# 12360 - North Penrith Stages 2B & 2C Development Application

## RESPONSE TO AGENCY SUBMISSIONS

Plotted: 16 October, 2012 3:27:08 PM File Name: J:\9470\DA - Development Application Approval Plans\stage 2B-2C\9470DA20.dwg

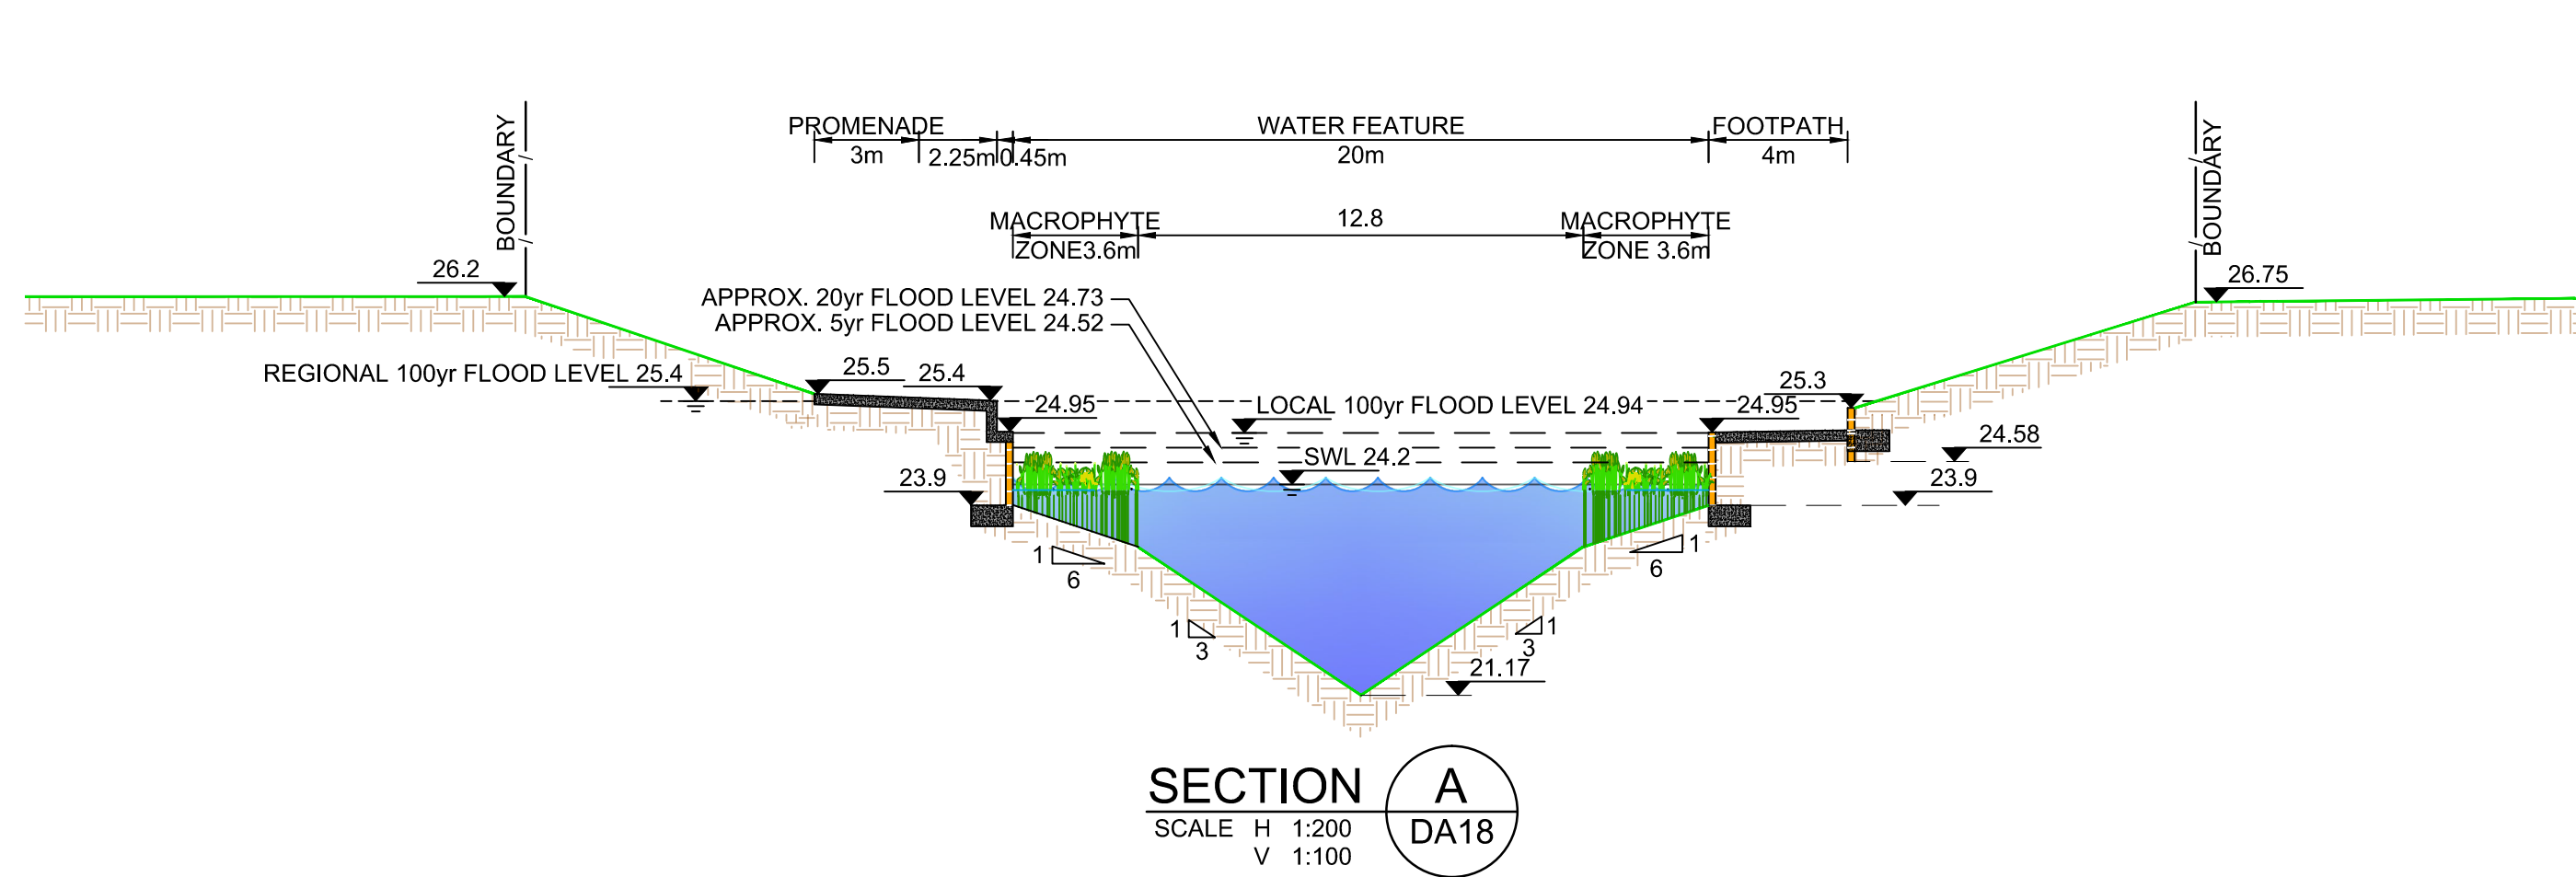
<ul style="list-style-type: none"> <li>The proposed channel is likely to have limited water quality benefits due to its design and lack of vegetation.</li> </ul>	<ul style="list-style-type: none"> <li>The central water feature and wetland have been designed as an integrated system to meet relevant water quality targets, as detailed and confirmed by the Water Cycle Management report.</li> </ul>
<ul style="list-style-type: none"> <li>There is likely to be an issue with sedimentation of the channel which will ultimately result in long term management issues with regard to algae growth. Detention ponds such as the one propose are commonly associated with algae management and unwanted vegetation management issues. The proposed water reticulation system and reliability of aerators will be critical to effective management of the canal and failure would likely result in management issues.</li> </ul>	<ul style="list-style-type: none"> <li>The inclusion of GPT's at all discharge points into the central water feature will reduce the sediment load entering the system. The system has been designed with best practice management principles and is considered to be a robust and functional system to manage algal growth.</li> </ul>

NORTH PENRITH
STAGE 2B & 2C
ROAD TYPICALS

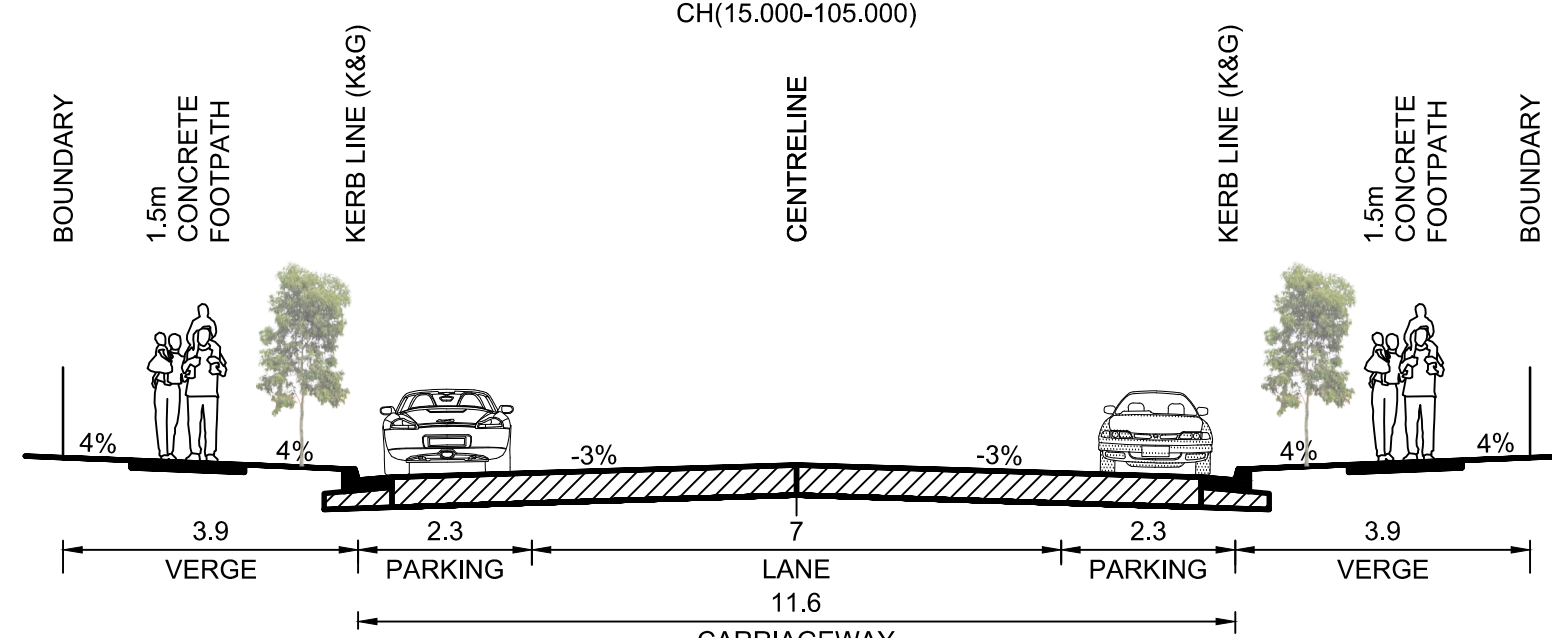
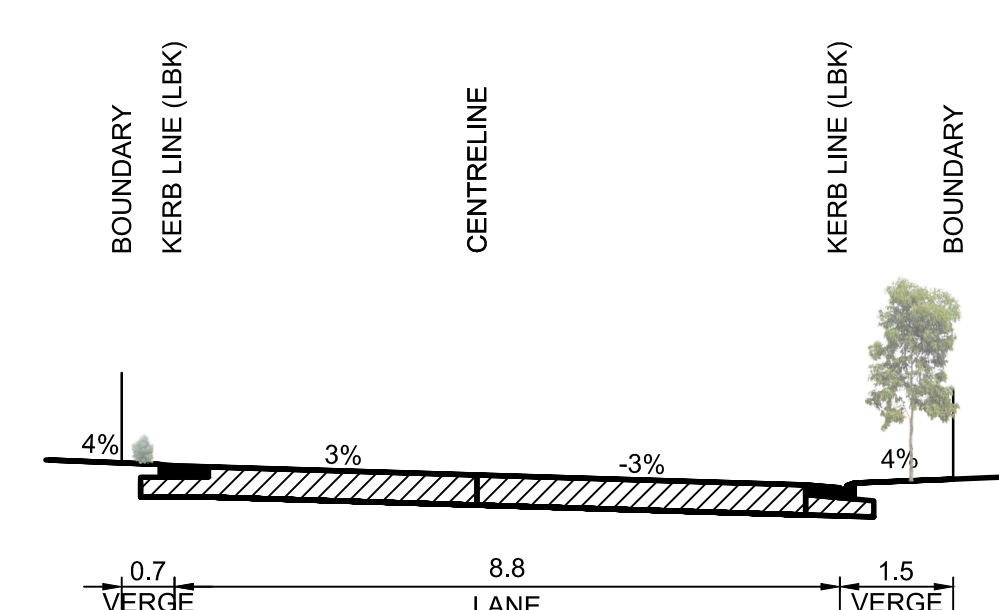
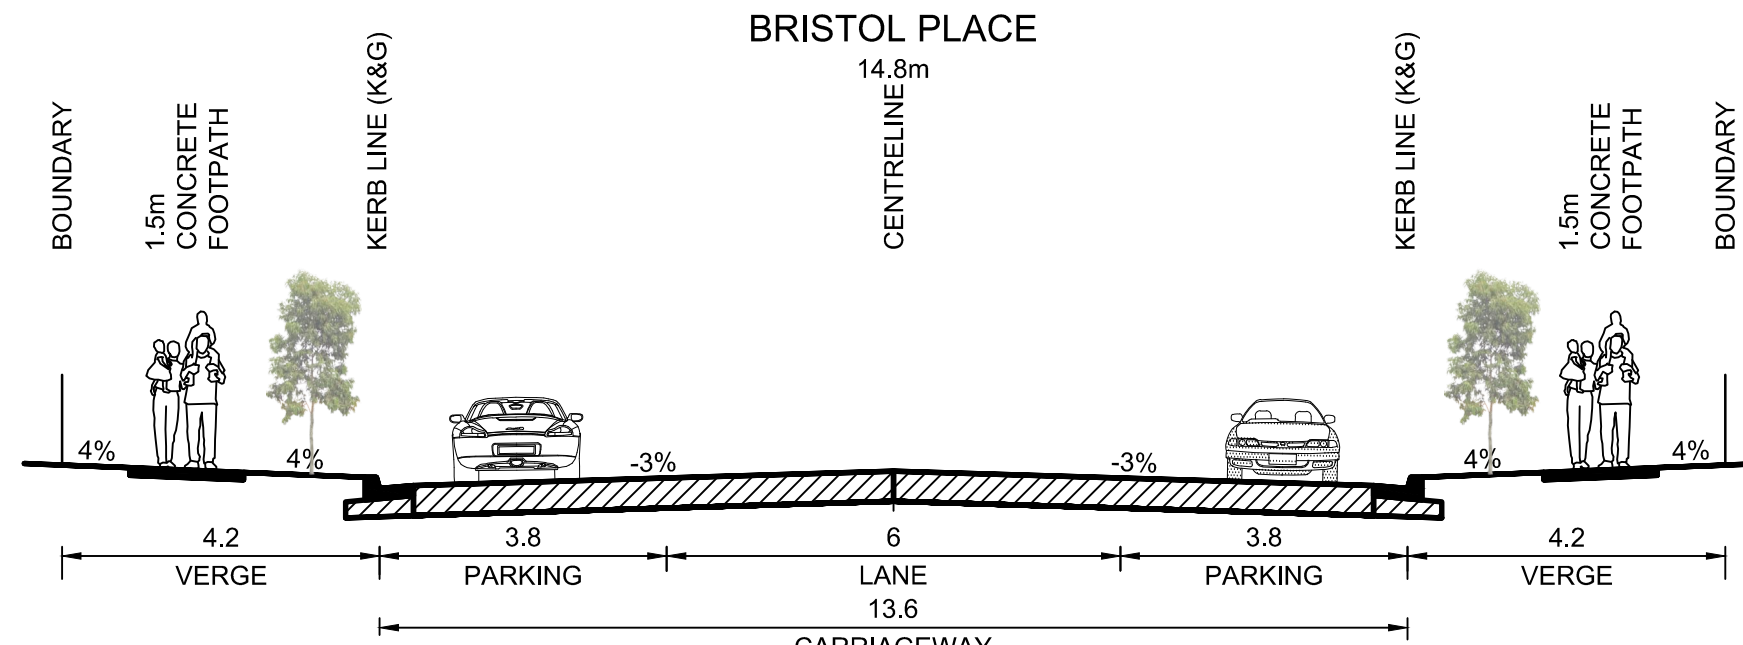
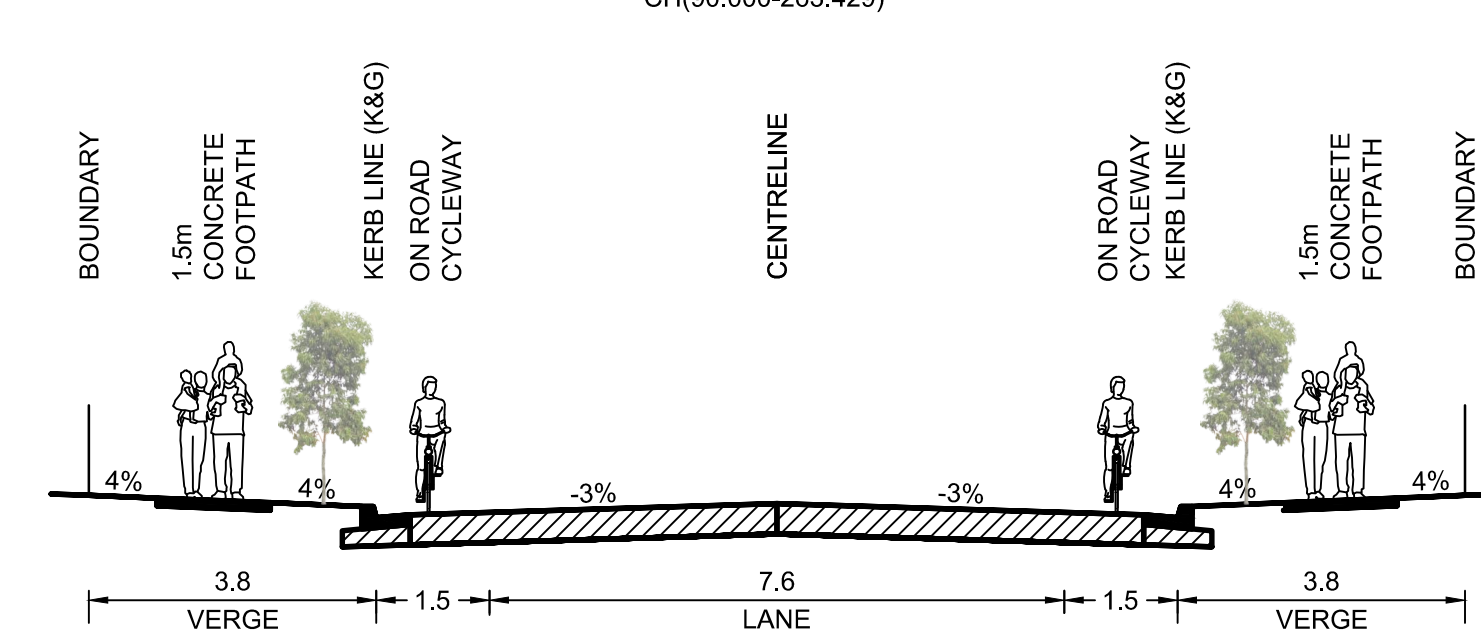
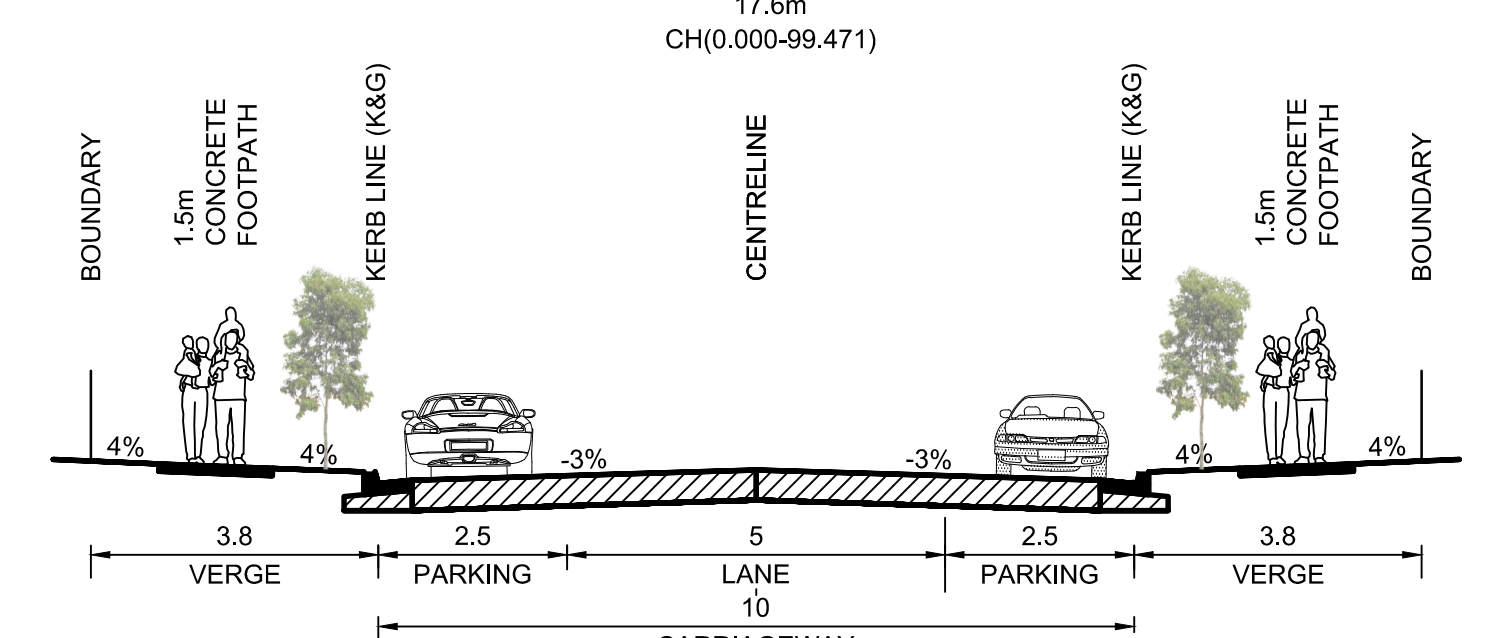
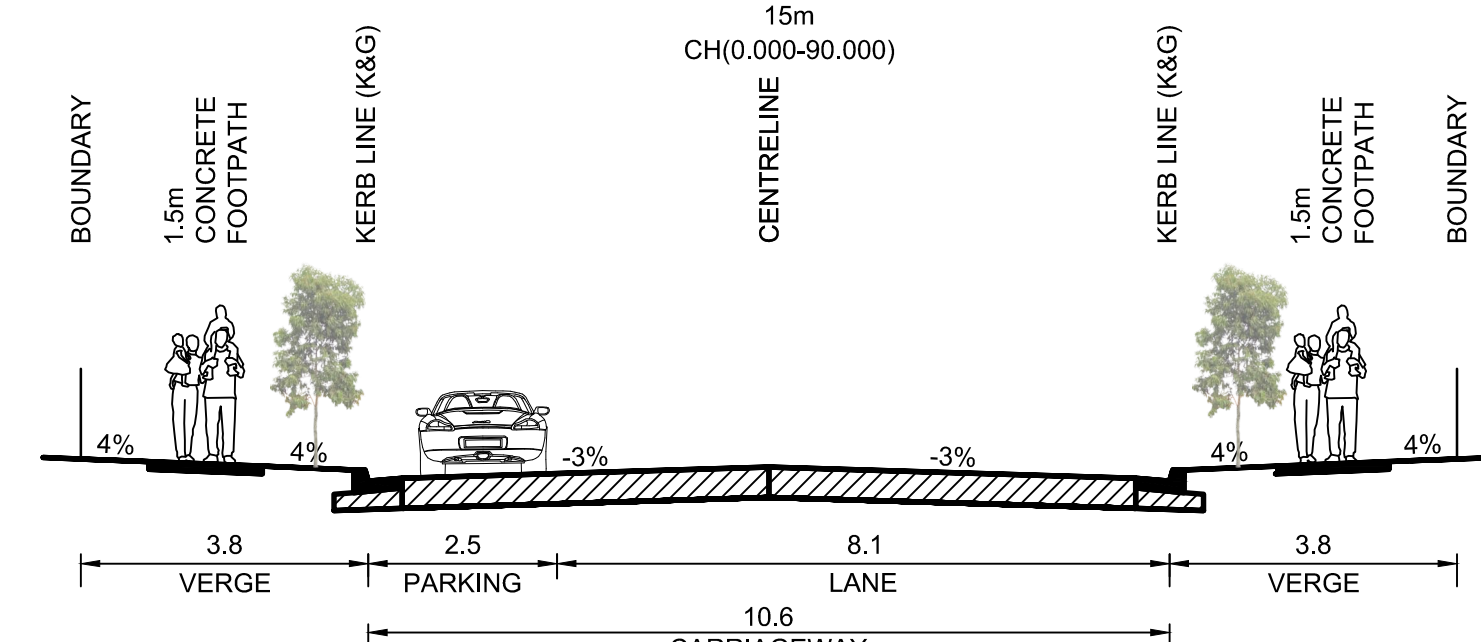
<ul style="list-style-type: none"> <li>Street cross sections are inconsistent with Council standards. Council's standard is 1.5m, however this path in a 3.6m verge means there is insufficient space for street trees. Also, there are both 3.8m and 3.9m verge widths.</li> </ul>	<ul style="list-style-type: none"> <li>The proposed street cross sections are consistent with those approved under the Concept Plan Approval. There are only minor adjustments where new street cross sections need to integrate with existing conditions (such as on Thornton Drive and on Combewood Avenue at the interface with the commuter car park).</li> <li>1.5m footpaths are provided in all locations, and street trees are still provided within the 3.6 verge.</li> </ul>
<ul style="list-style-type: none"> <li>Street trees should take into account and not compromise the levels of lighting from street lights.</li> </ul>	<ul style="list-style-type: none"> <li>Noted.</li> </ul>

<ul style="list-style-type: none"> <li>The proposed widths of some of the roads (2.3-2.5m) and intersection layouts would permanently inhibit buses or larger service vehicles. It is important consideration be given to providing roads and intersections that can support bus manoeuvrability in accordance with the relevant standards.</li> </ul>	<ul style="list-style-type: none"> <li>As above.</li> <li>The relevant roads and intersections for the dedicated bus route approved in the Concept Plan are designed to accommodate bus movements.</li> </ul>
<b>NSW TRADE AND INVESTMENT RESOURCES &amp; ENERGY – MINERAL RESOURCES BRANCH</b>	
<ul style="list-style-type: none"> <li>The Mineral Resources Branch (MRB) has no objection to the North Penrith Mixed Use Development Stages 2A, 2B, 2C, 2D and 3B. Other divisions of NSW Trade and Investment including Agriculture, Fisheries and Forests NSW may provide advice in separate correspondence.</li> </ul>	<ul style="list-style-type: none"> <li>Noted.</li> </ul>
